Development Facilitation Team (DFT) – Review Comments

Project No: PR-2024-010040 Date: 03/13/2024 Agenda Item: #1 Zone Atlas Page: C-17

Request: Adjust Lot Line between Lots 3 & 4.

Application For: SD-2024-00040 – Preliminary/Final Plat

PLAT OF  
LOTS 3-A & 4-A  
HORIZON VILLAGE  
(BEING A REPLAT OF LOTS 3 & 4, HORIZON VILLAGE)  
WITHIN THE  
ELENA GALLEGOS GRANT  
PROJECTED SECTION 14  
TOWNSHIP 11 NORTH, RANGE 3 EAST, N.M.P.M.  
CITY OF ALBUQUERQUE  
BERNALILLO COUNTY, NEW MEXICO  
DECEMBER, 2023

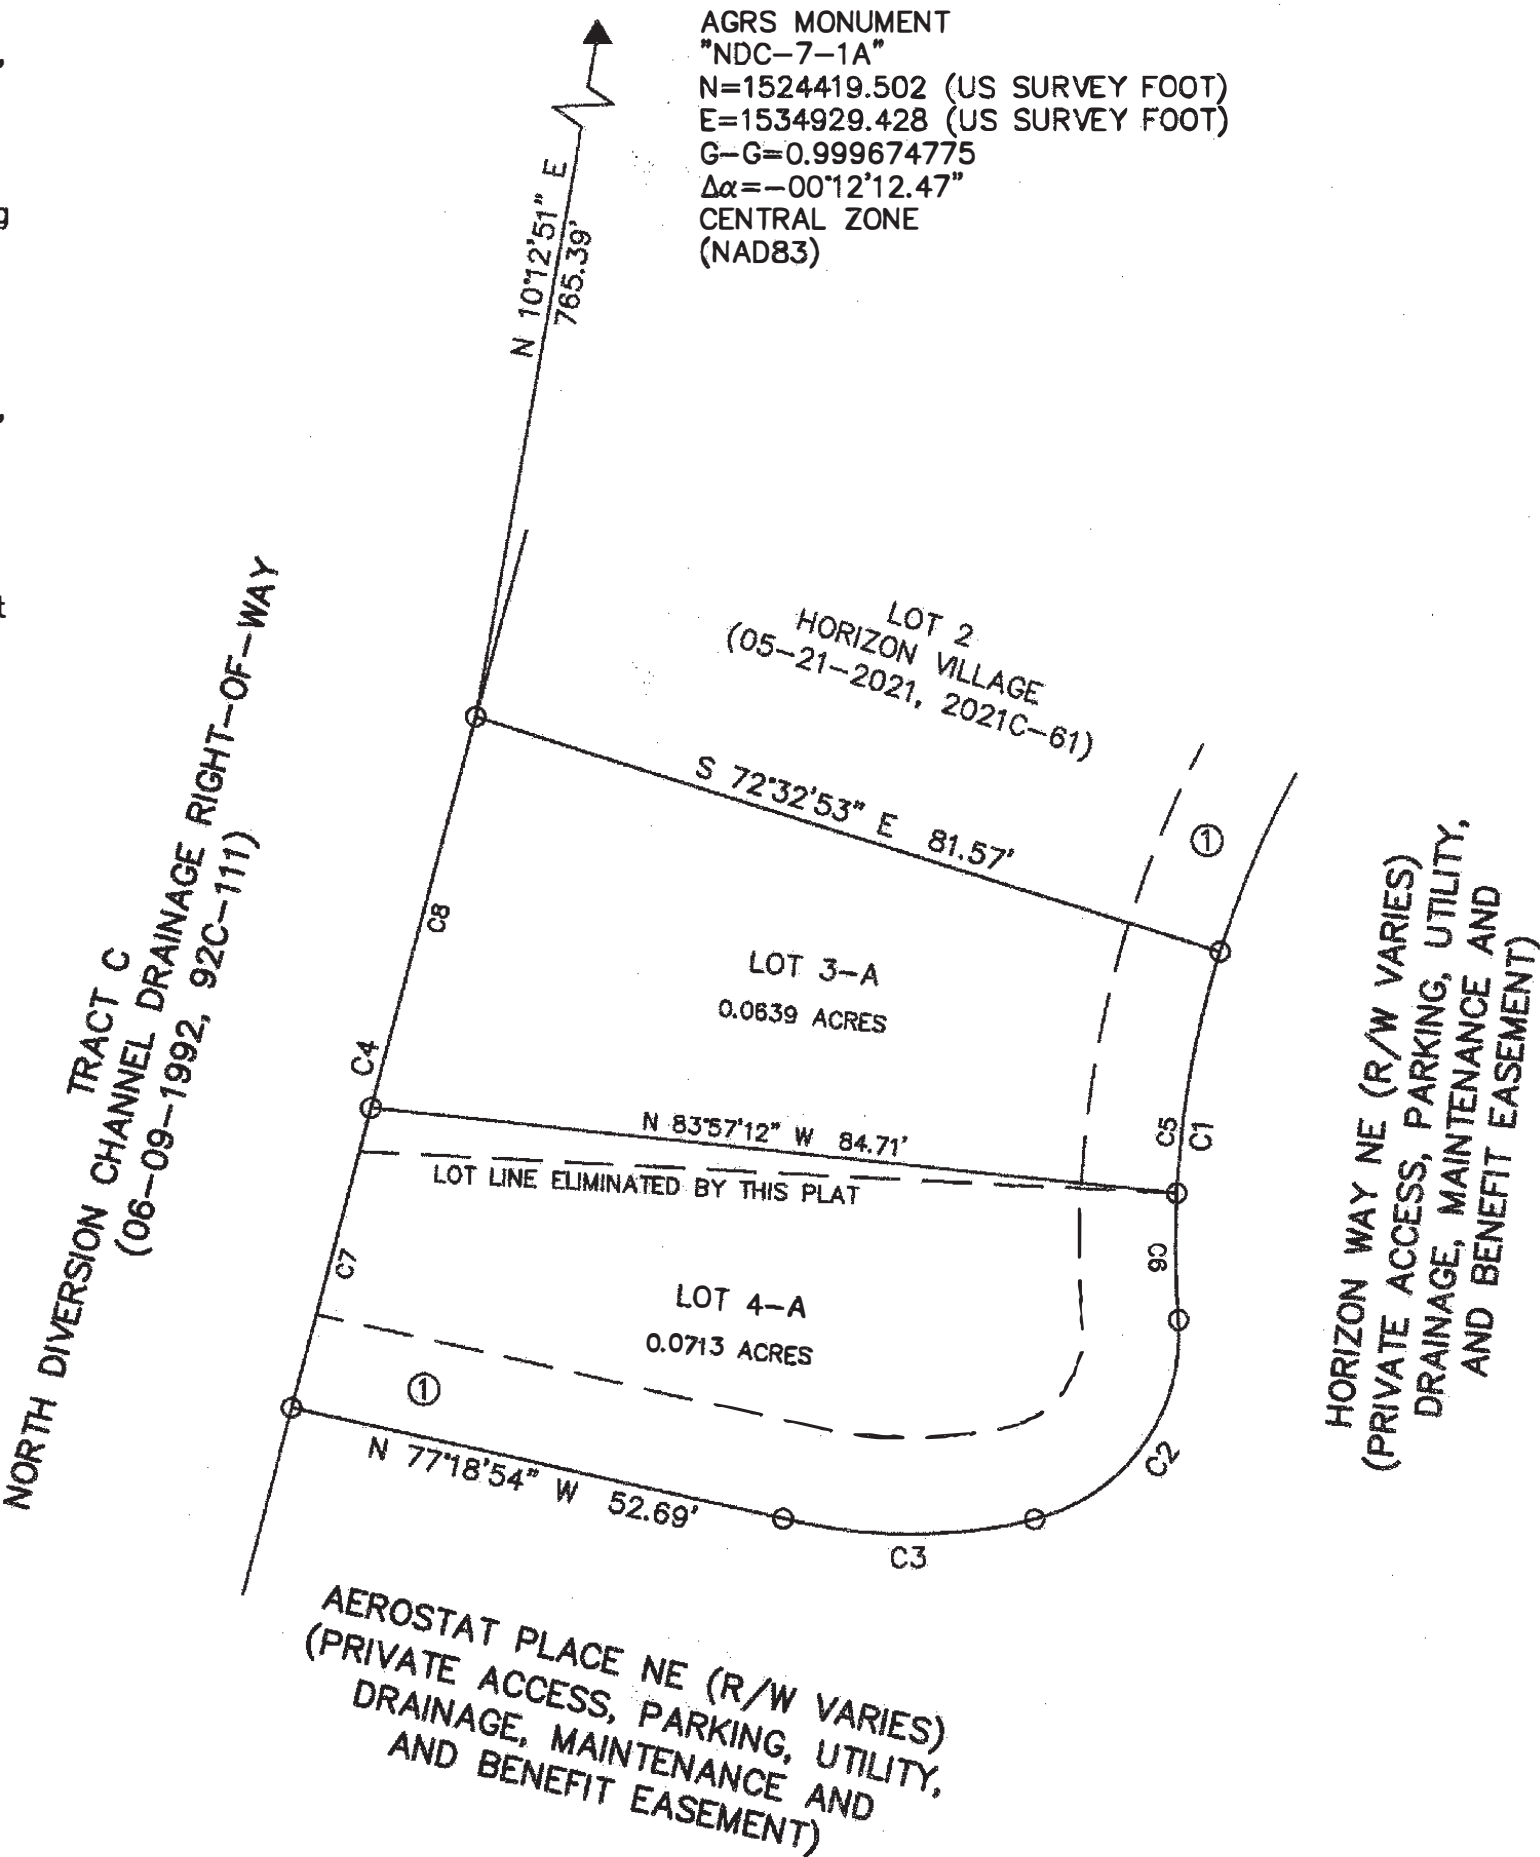
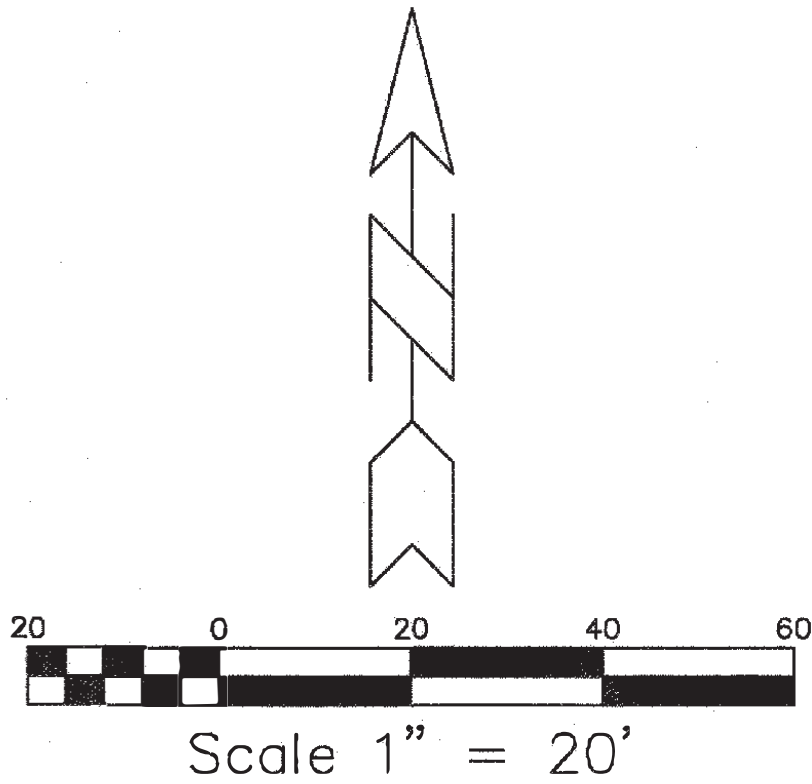
1. Property is zoned R-ML and. All dimensional standards for lot size and width must be met as per IDO section 5-1(C), Table 5-1-1, as well as setback and height requirements for future development.
2. Lot width measurements should be shown on plat to ensure minimum lot widths are being met.
3. Property is located within an Area of Consistency. If plan is to develop property with low-density residential dwelling(s), then the Contextual Lot size standards would apply and must be between .0630 to .1051 acre. Proposed revised lot sizes are within the allowed Contextual lot size standards for low-density residential.
4. For Future Development: Property is located within Sub Area 2 of CPO-10, North I-25 Overlay zone, and must meet all development standards, accordingly.
5. CE has no further comments and no objections.
